Consultation Response from: KC Environmental Health (Pollution & Noise Control)
2026/90655 - Huddersfield Textile Training, Textile House, Red Doles Lane
Discharge of details reserved by conditions 6 (Phase I Desk Study Report), 13 (intrusive investigation), 14 (intrusive site investigations) on previous permission 2024/93250 for erection of warehouse extension for storage of product containers/pallets
Date Responded:
Monday, 13 April 2026

Overall Recommendation: Environmental Health do not recommend discharge of Condition 6 for the reasons outlined below.

18 Mining and ground workings

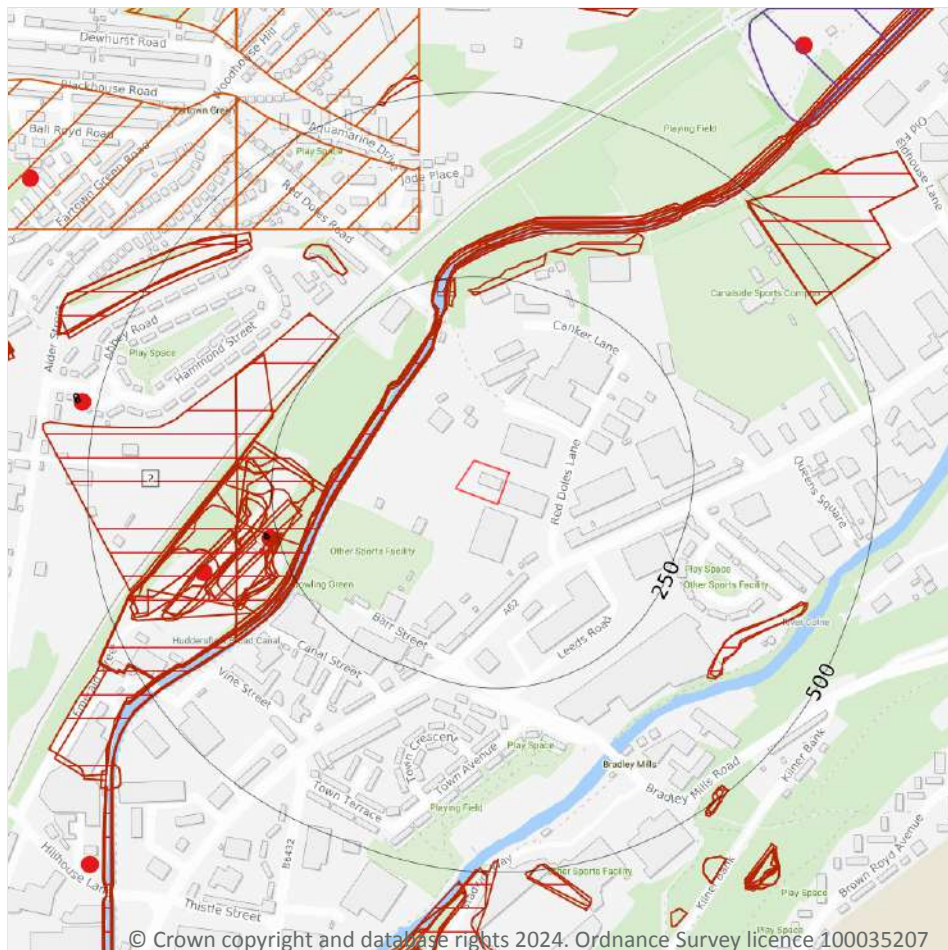
This contradicts the information presented in the appended Groundsure report which states:

Location	Details
On site	The site is located within a coal mining area as defined by the Coal Authority. A Consultants Coal Mining Report is recommended to further assess coal mining issues at the site. This can be ordered directly through Groundsure or your preferred search provider.

No reference is made to the above or to the potential presence for ground gas within the report.

Based on the errors and inaccuracies identified within the report, the information presented cannot be considered accurate, and the report requires further review and resubmission.
